From: Simon Power
Sent: 07 February 2008 10:44
To: Planning.Responses
Cc: Brian Holland
Subject: RE: Planning Consultation on: BE/1/08/

I refer to the above Outline Planning Application, which has been sent to me for Drainage comments.

APPLICATION NO:	BE/1/08/
Registered:	07-JAN-08
Site Address:	Land at Oldlands Farm Shripney Road Bognor Regis
Grid Reference:	494300-101410
Category:	Plan Applicat'n
Description of Works:	Outline application for mixed use employment (Class B1 high quality business park comprising up to 19,500 SQM gross floorspace) and retail (Class A1 grocery store up to 4,459 SQM net sales area) together with parking, new highway & associated servicing, infrastructure & landscaping - This application is a departure from the development plan and is accompanied by an environmental statement

TITLE
Oldlands Farm Business Park
Bognor Regis
Parameters Assesment Plan

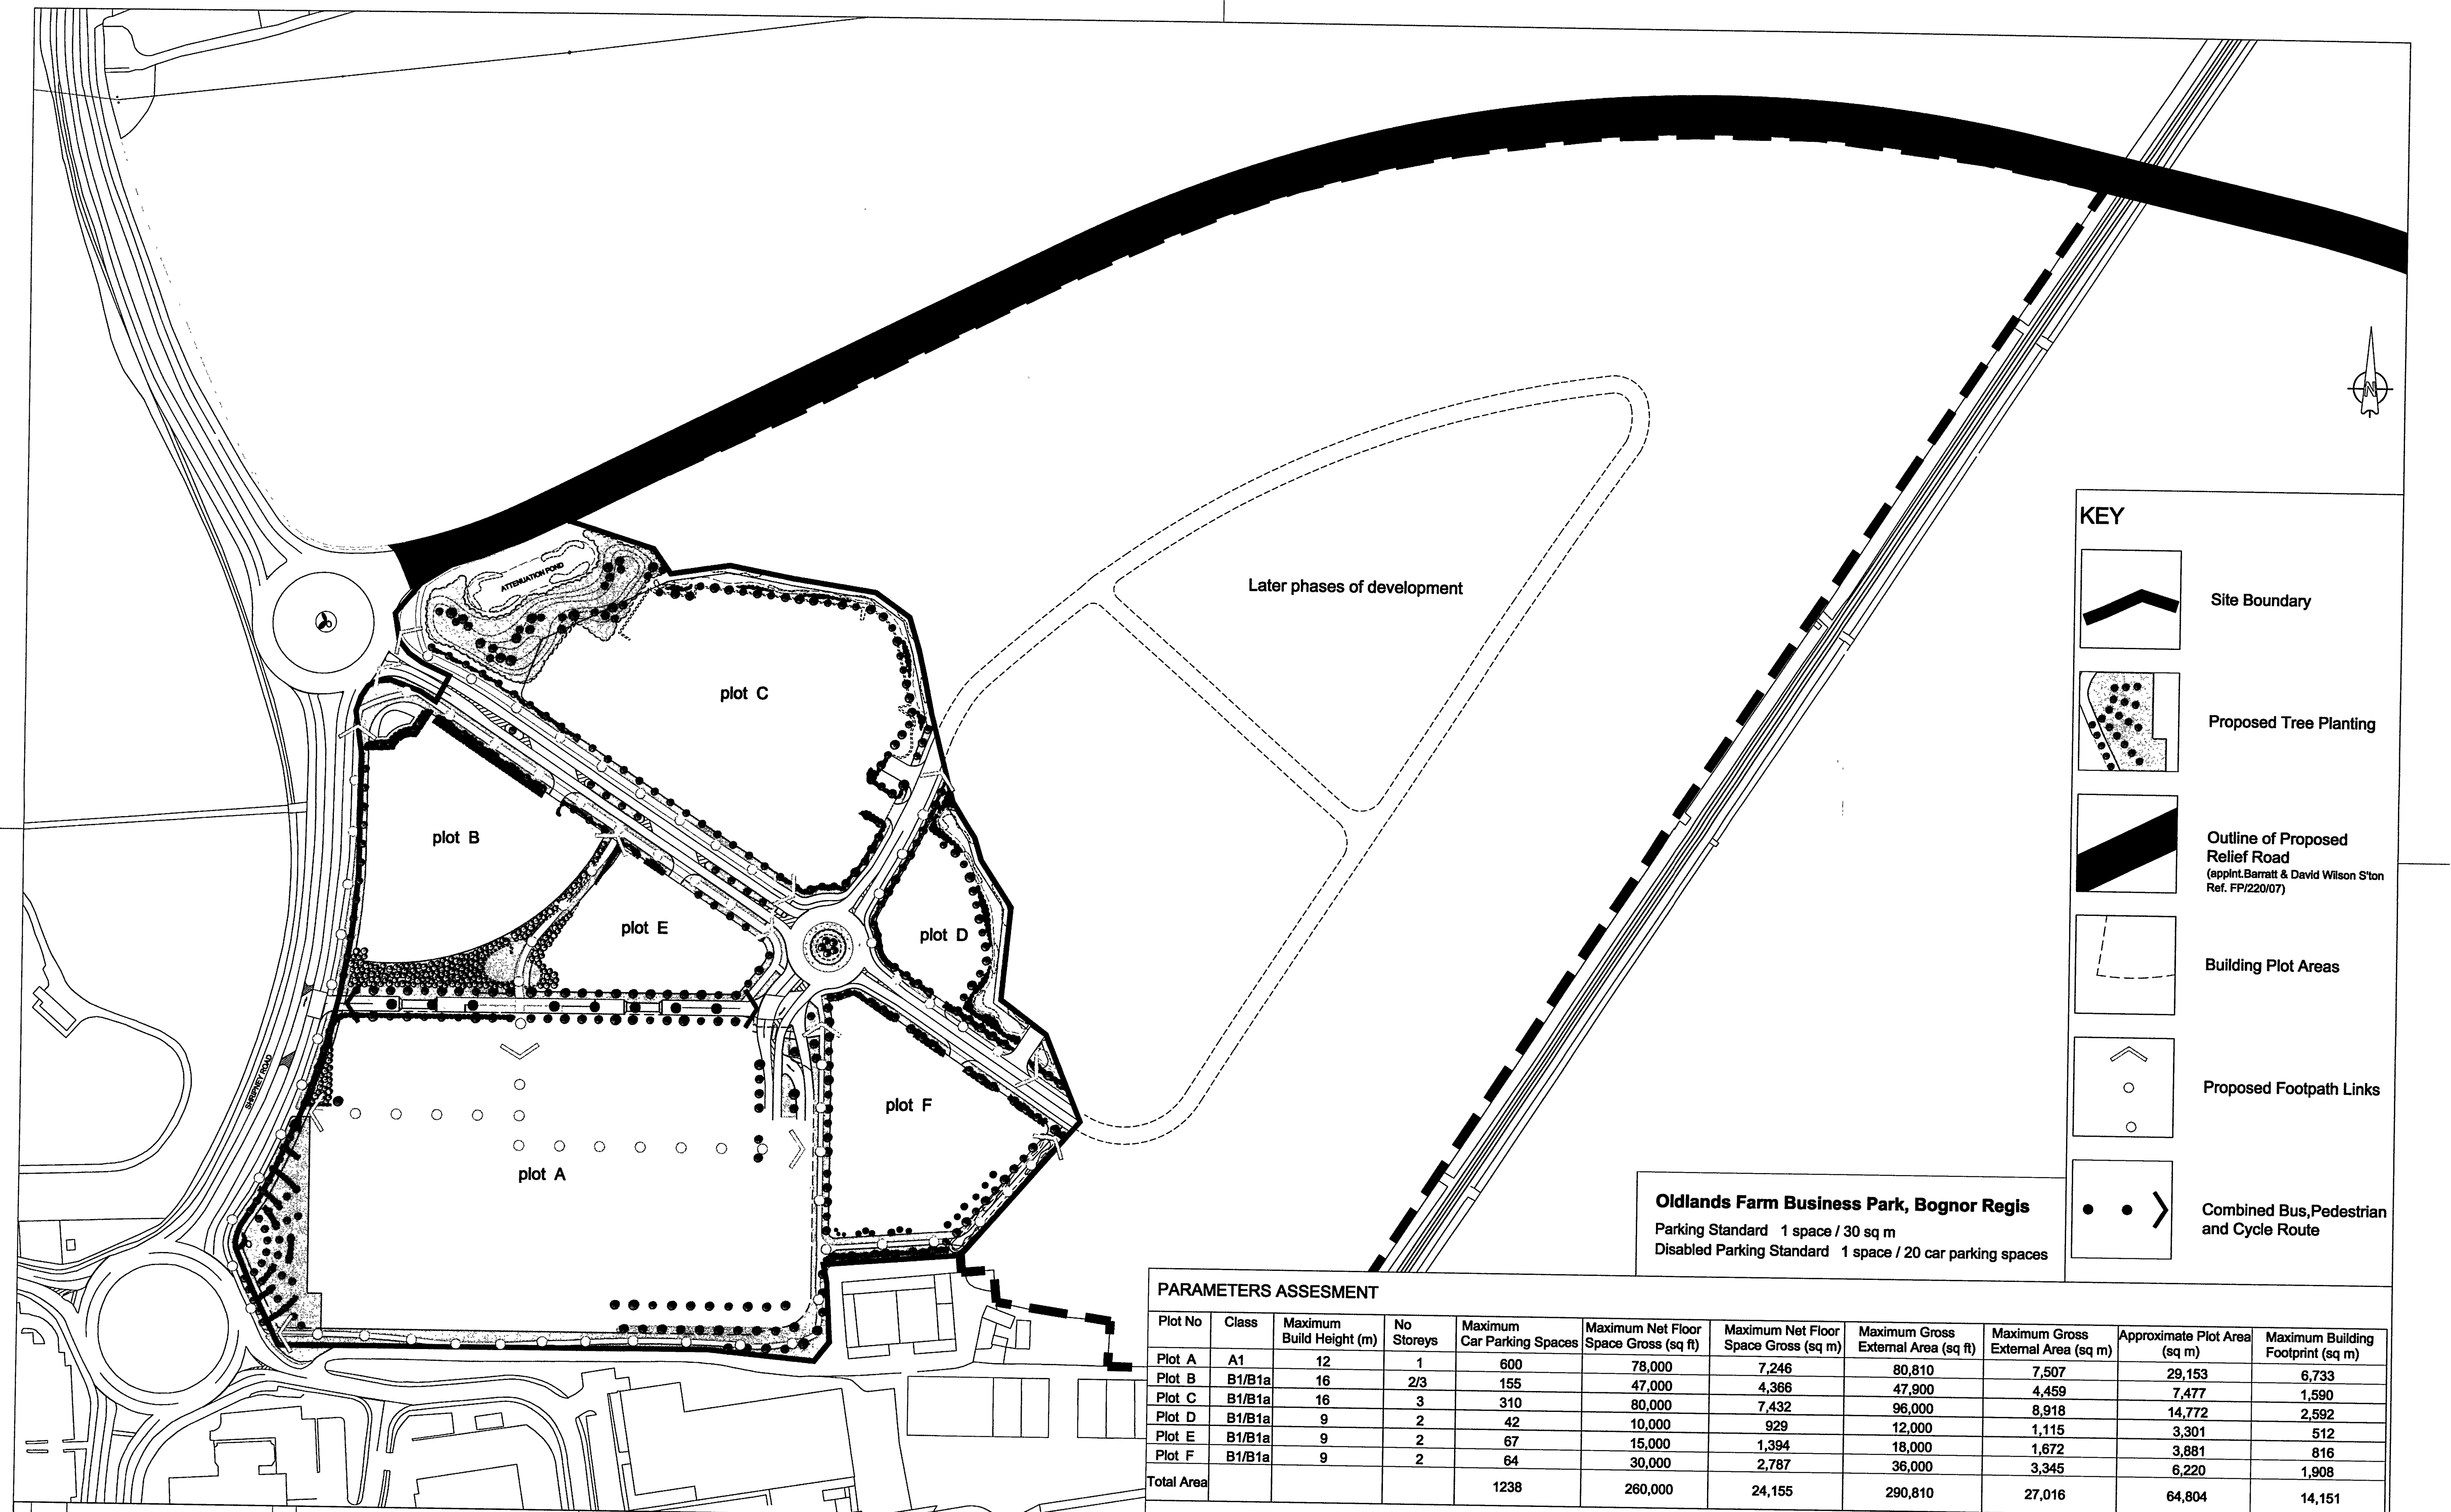
- Twelve months of groundwater table monitoring will be required, at several locations within the route of the proposed storage ditch. This data is required to determine the highest annual level of the groundwater table. The groundwater table is known to exist at a shallow depth within the site. It will be necessary to design the base of the proposed storage ditch, above the highest recorded groundwater table, and to include a safe margin between the groundwater table and base of the proposed storage ditch. This is to ensure that the designed storage capacity of the ditch, will not be occupied by a high groundwater table at any time, taking up some of the storage capacity at the time when it most needed.
